The Secretary
NSW Department of Planning, Industry and Environment

12 May 2021

I refer to the Department's below email of 10 May 2021 regarding the notice of exhibition of the Environmental Impact Statement (EIS) for State Significant Development SSD-9579147 Pendle Hill High School Redevelopment at 66 Binalong Road, Toongabbie (Lot 101 DP 1141329). Submissions need to be made to the Department by 8 June 2021.

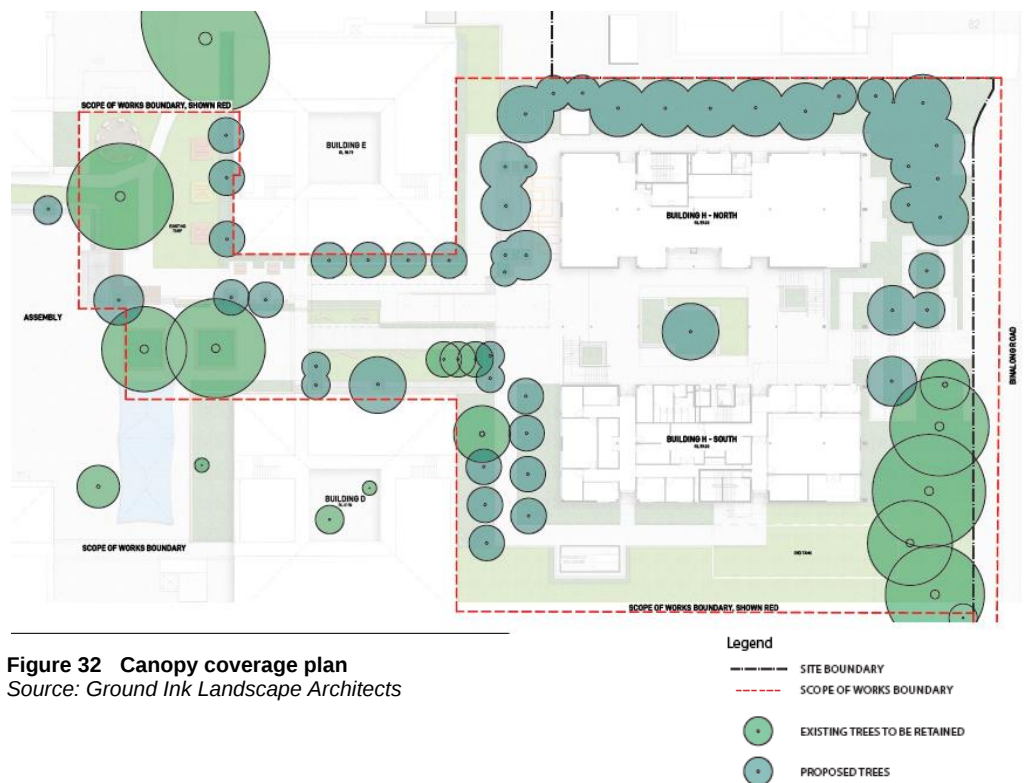
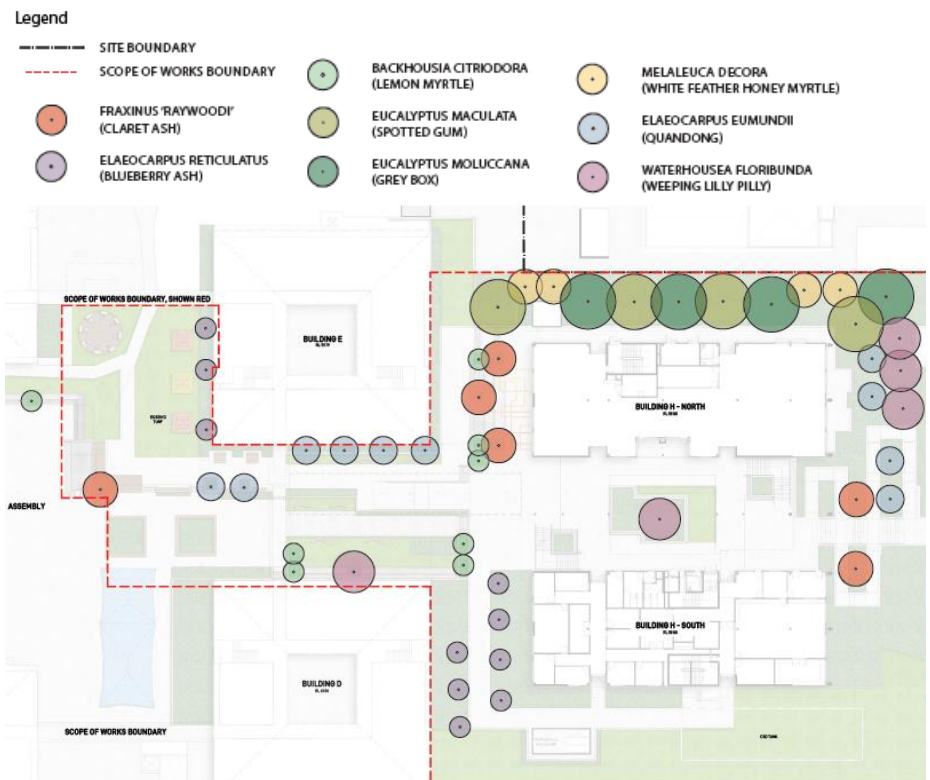
As shown in the following extract of the Landscape Master Plan the proposed extensive tree planting between the padmount substation and Building H – North will need to reconsider if the proposed plantings achieve the foregoing requirements. In addition, as per Endeavour Energy's previous submission, appropriate planting needs to occur in proximity of the overhead power lines to the Binalong road road frontage needs to be considered.
